DESCRIPTION OF REQUEST: FINAL SIGN-OFF OF AN EPC APPROVED SITE PLAN FOR BUILDING PERMIT

OFFICIAL NOTIFICATION OF DECISION

October 14, 2016

**Project# 1002717
16EPC-40045 Site Development Plan for Building Permit**

SP1

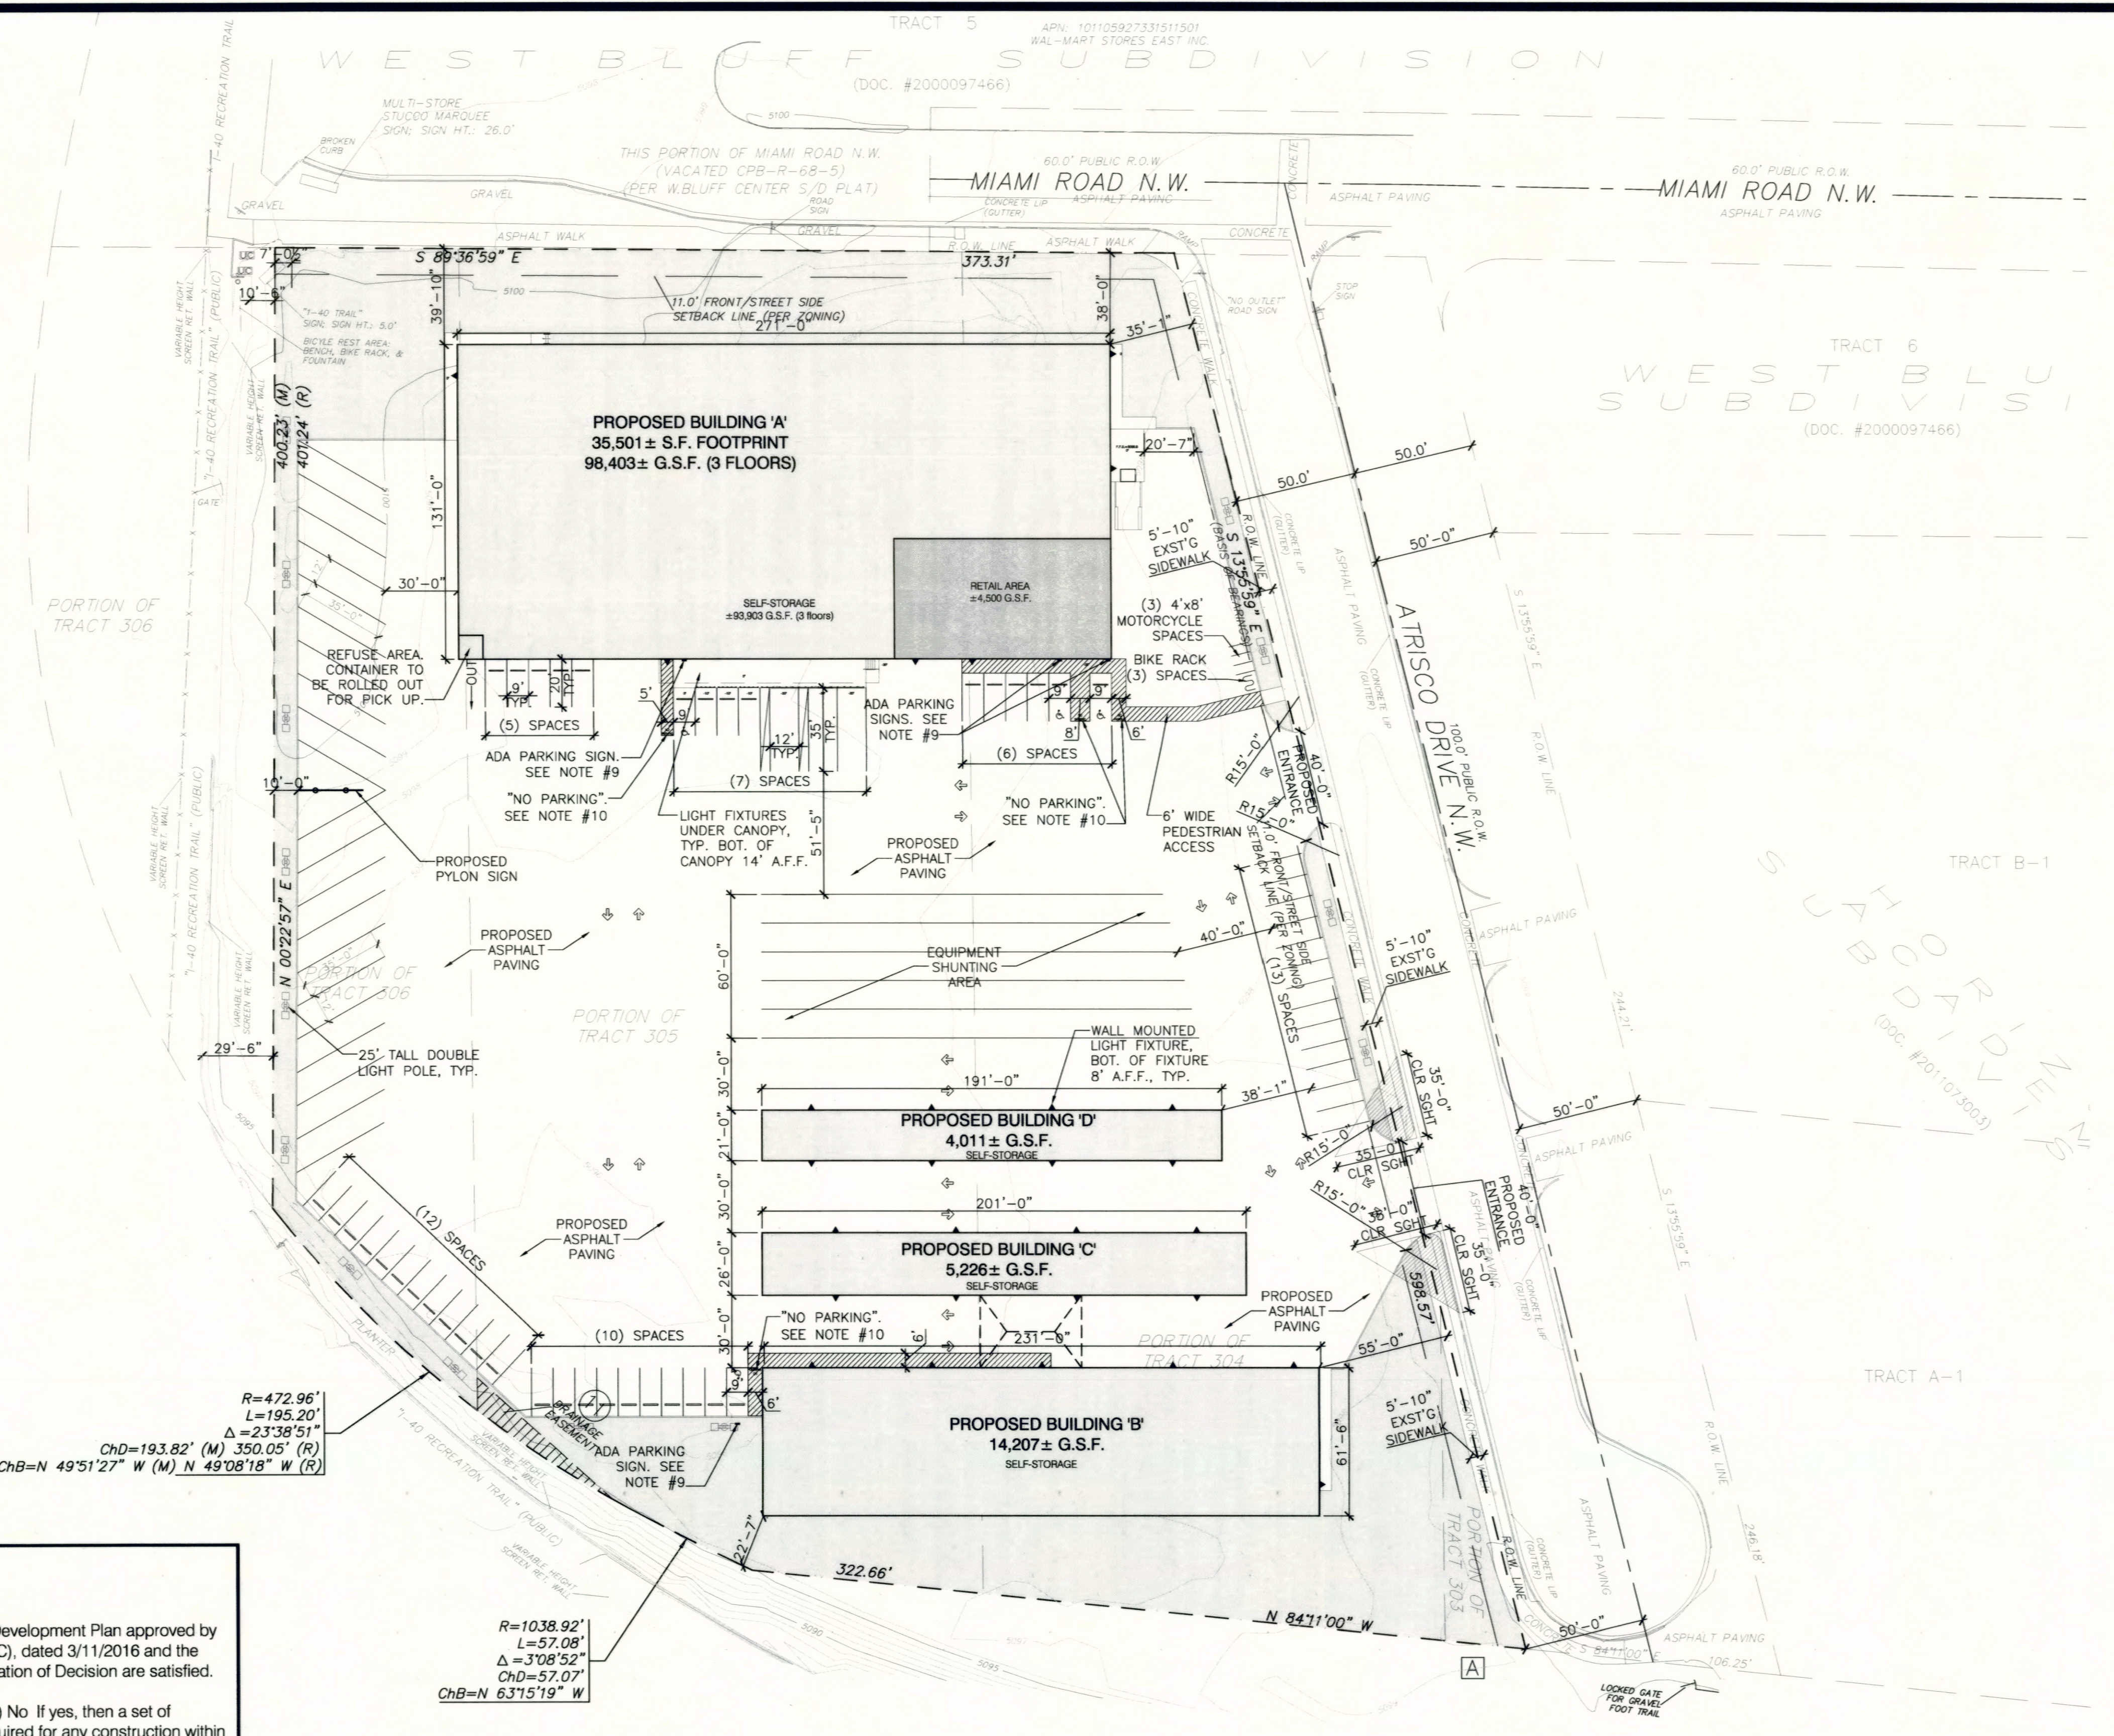
2. Prior to application submittal to the DRB, the applicant shall meet with the staff planner to ensure that all conditions of approval are met.
3. The applicant shall include detailed drawings demonstrating that lighting for the subject site will conform to Section 14-16-3-9 (Area Lighting Regulations) of the Zoning Code must be included on Sheet SP1 or Sheets A2 or A3.

4. The applicant shall add a note to Sheet SP1 that all onsite lighting shall conform to the State of New Mexico Night Sky Protection Act (74-12-1 to 74-12-10 NMSA 1978).

5. The general notes section of the site plan Sheet SP1 (General Note 1) states that parking lot lighting shall be a maximum of 20' and comply with the Unser/McMahon Village Center North Site Plan for Subdivision.

- a. The applicant shall remove the reference to the Unser/McMahon Village Center North Site Plan for Subdivision as noted on Sheet SP1 (General Note 1).

- a. The number of parking spaces required by the zoning code does not match the number of spaces provided. Please and clarify the total number of spaces required and provided.
- b. The ADA accessible parking sign must have the required language per 66-7-352.4C NMSA 1978 "Violators Are Subject to a Fine and/or Towing." Please call out detail and location of HC signs.
- c. The ADA access aisles shall have the words "NO PARKING" in capital letters, each of which shall be at least one foot high and at least two inches wide, placed at the rear of the parking space

WEST BLUFF BUSINESS CENTER	DRAWN BY DY
	GRADING AND DRAINAGE PLAN	DATE 11/28/16
	TERRA WEST, LLC 5571 MIDWAY PARK PLACE NE ALBUQUERQUE, NM 87109 (505) 858-3100 www.tierrawestllc.com	2016061-GRB
		SHEET # GR-1
		JOB # 2016061

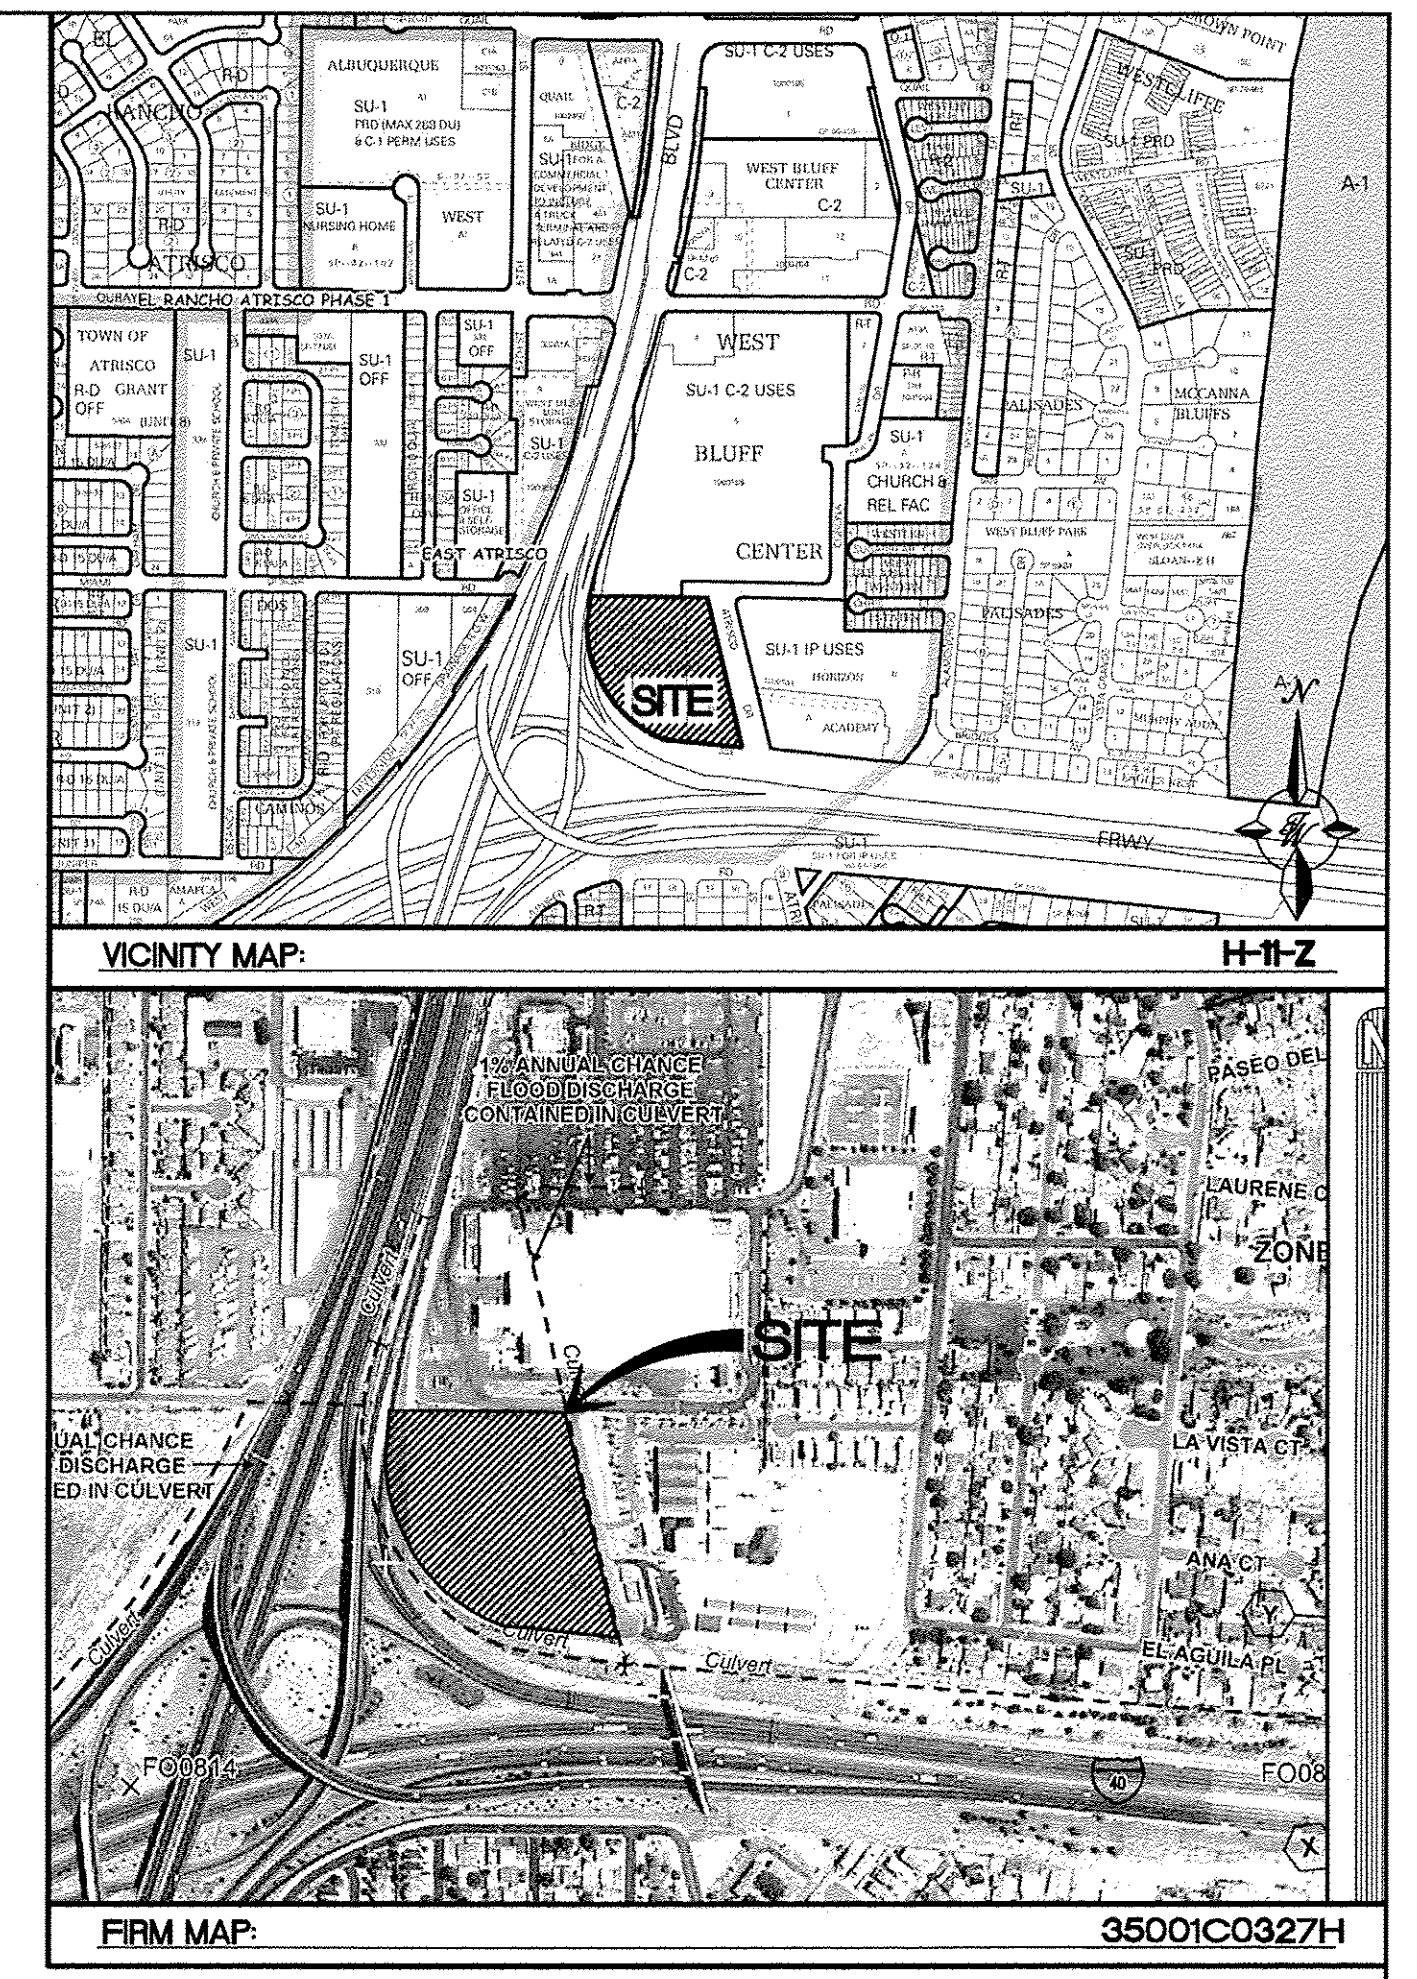
- a. Need coordination with Parks and Recreation with regard to the grading and drainage plan for the site. Additional impervious surfaces combined with the steep slope at the southern edge of the property could result in additional erosion to the steep slope adjacent the property causing debris on the surface of the multi-use trail immediately below. This existing condition could worsen and cause risk to trail users as well as additional maintenance requirements for the Parks and Recreation Department. The Department requests that the grading and drainage plan include measures to reduce storm water runoff and erosion from the site along the southern end of the property.

- b. The Building Permit set will need to define how the smaller first flush pond adjacent to Building B will spill over into the larger pond (to keep spillover away from the slope). The flow arrows give some indication, but the landscaping doesn't appear to yet reflect a defined swale to the larger pond. Consider eliminating the smaller pond and extending a swale/pond from the larger to keep the volume farther away from the slope.
- c. At DRB, clarify how the CBC is utilized, is it detached from the 54" line?
